Consultee Comments for Planning Application 21/00131/FULL

Application Number: 21/00131/FULL

Address: Flat 1 37 Westbourne Terrace London W2 3UR

Proposal: Replacement of two courtyard ground floor windows with double glazed timber casement windows and installation of new flat rooflight to rear extension. (Linked to 21/00132/LBC)

**Ground Floor Plan**  
Scale 1:100 @ A3 | 1:50 @ A1

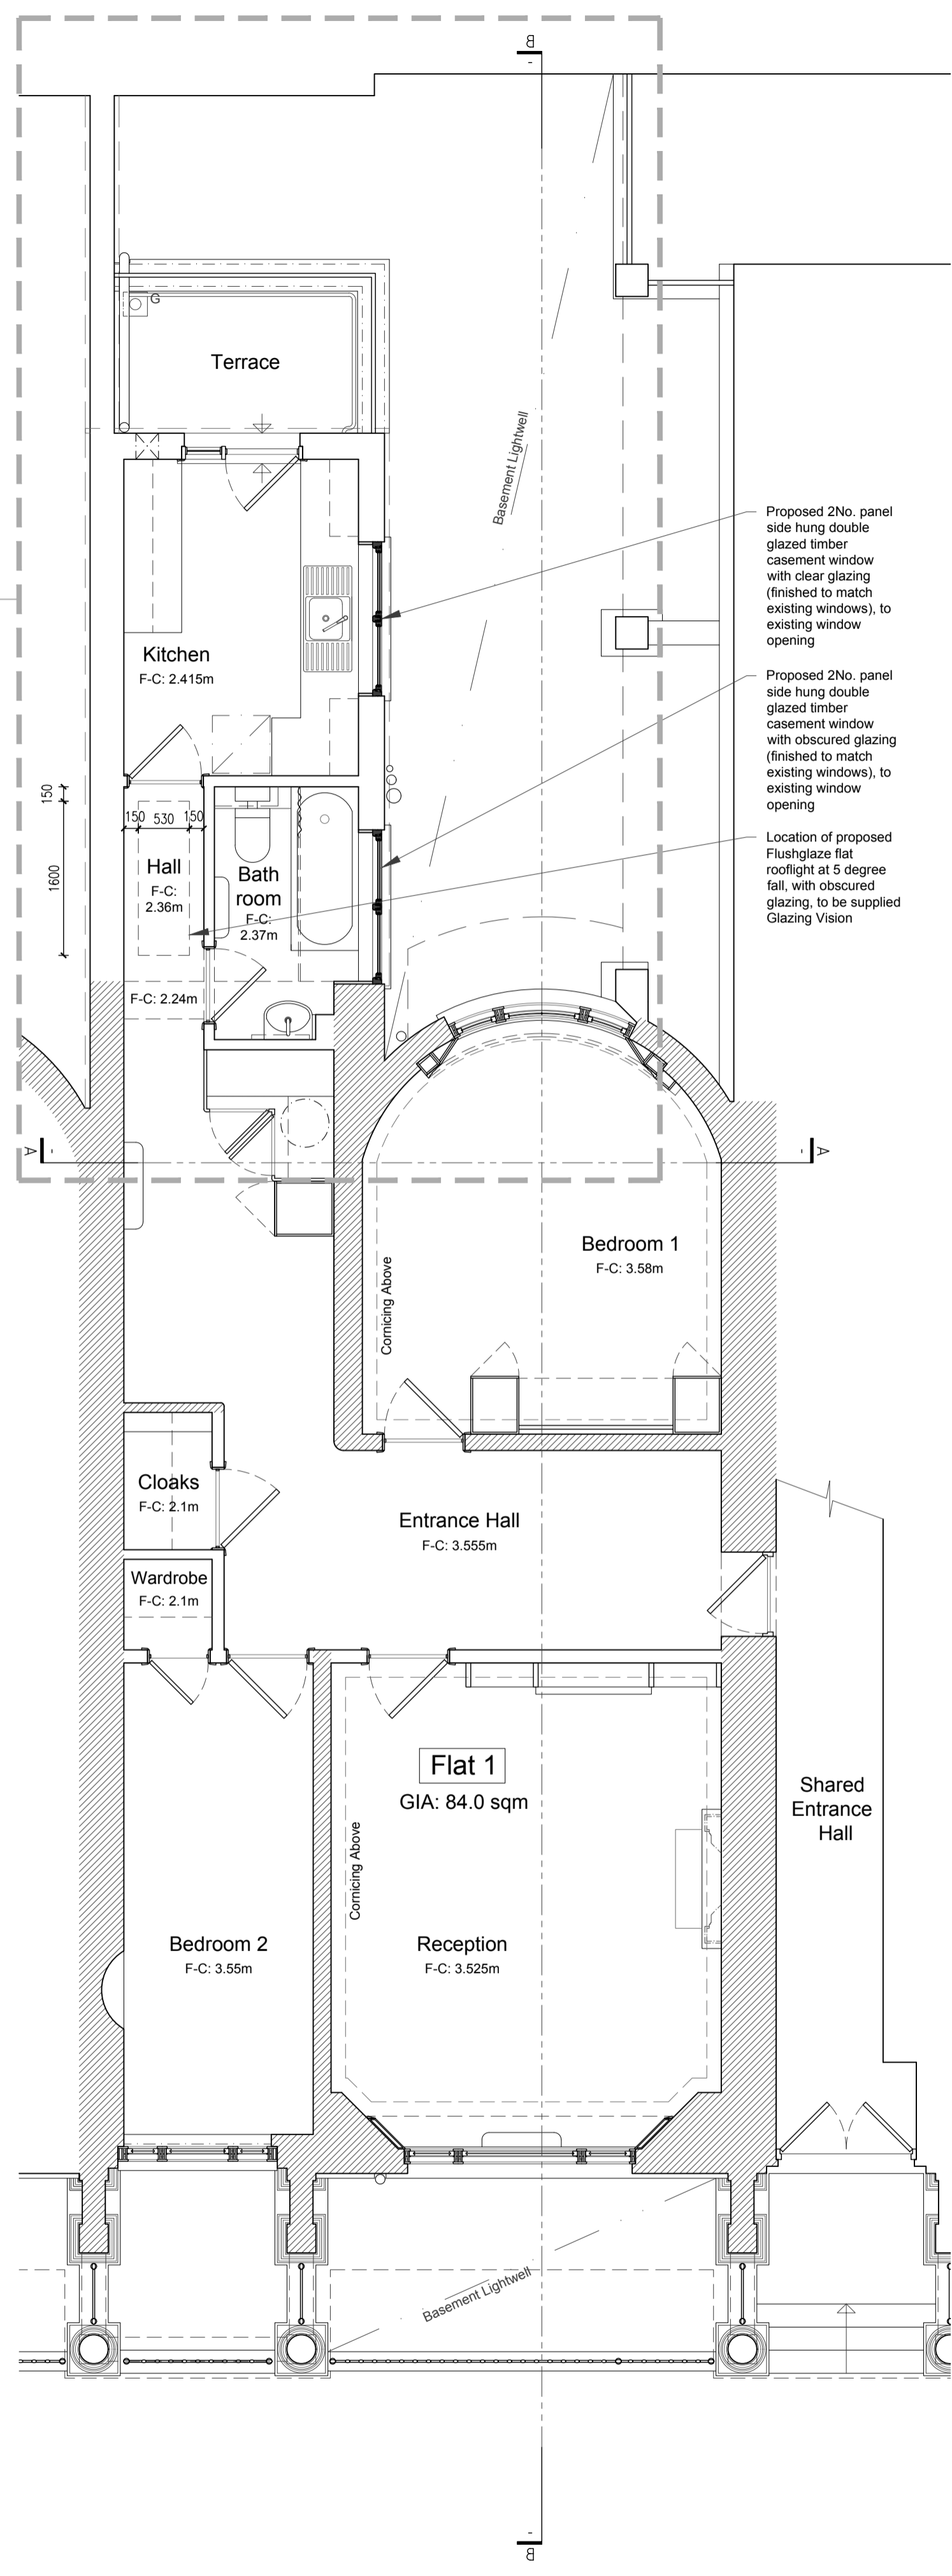
Replacement with timber framed windows is welcome, but on our understanding the proposed double glazing is contrary to policy for listed buildings. The listing appears to apply to the whole building, front and rear, albeit this rear extension is probably non original.

Single glazing would be fine.
